Recommendation Report for Lawful Development Certificate for a Proposed Use or Development**REF NO:** BR/290/20/CLP**LOCATION:** 43 Pevensey Road
Bognor Regis
PO21 5NY**PROPOSAL:** Lawful development certificate for a Proposed single storey extension to replace existing side extension and rear sun lounge.**DESCRIPTION OF APPLICATION**

Application for a certificate of proposed development for a single storey extension to replace existing side extension and rear sun lounge.

DRAWING NO PR 3

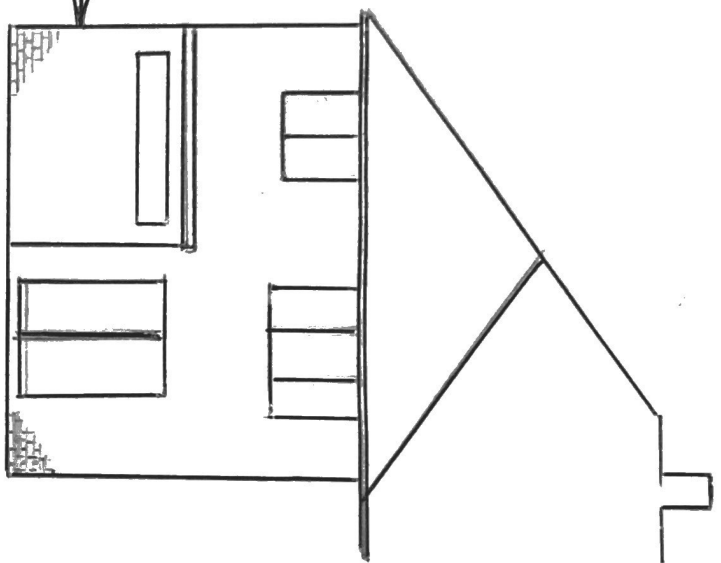
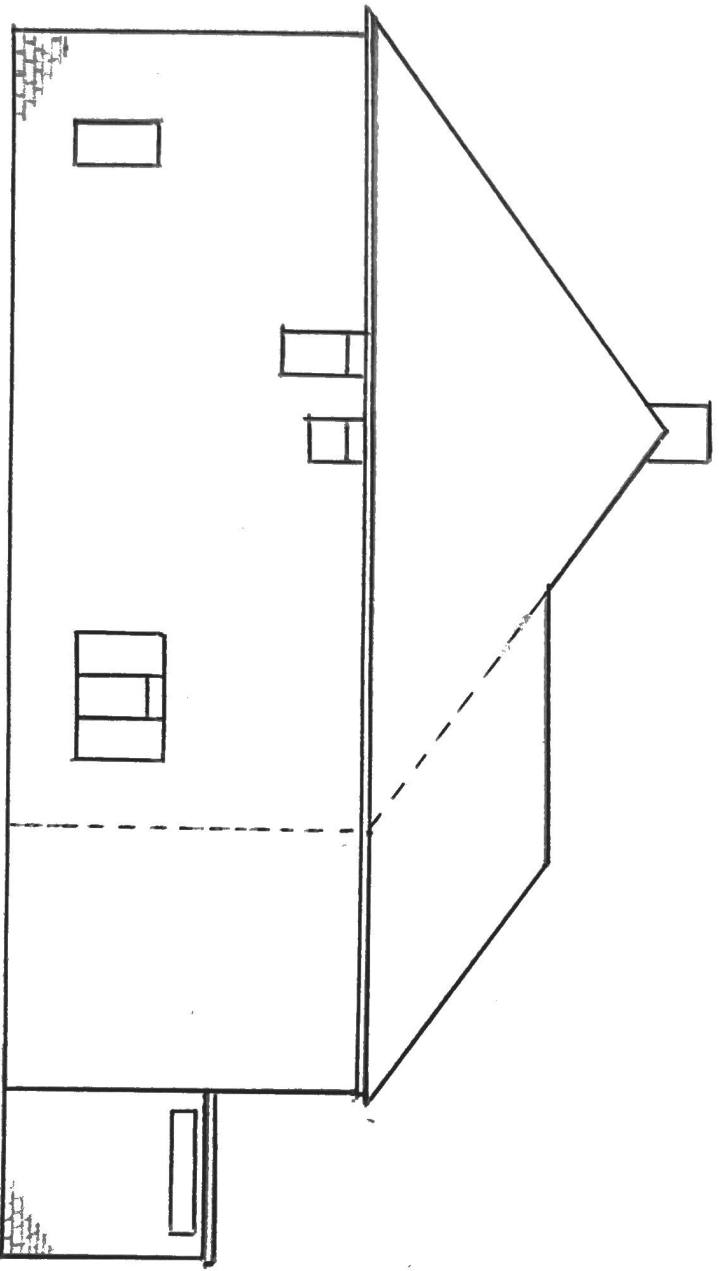
The proposed single storey rear extension fails to comply with relevant section (f) and subsequent technical guidance for part (g), in that at 6m in length the extension is subject to the Neighbourhood Consultation Scheme, and is therefore is not considered permitted development and as such requires the submission of an application for planning permission.

- The proposed development does not comply with limitations of Schedule 2 Part 1 Class A of the General Permitted Development Order 2015.
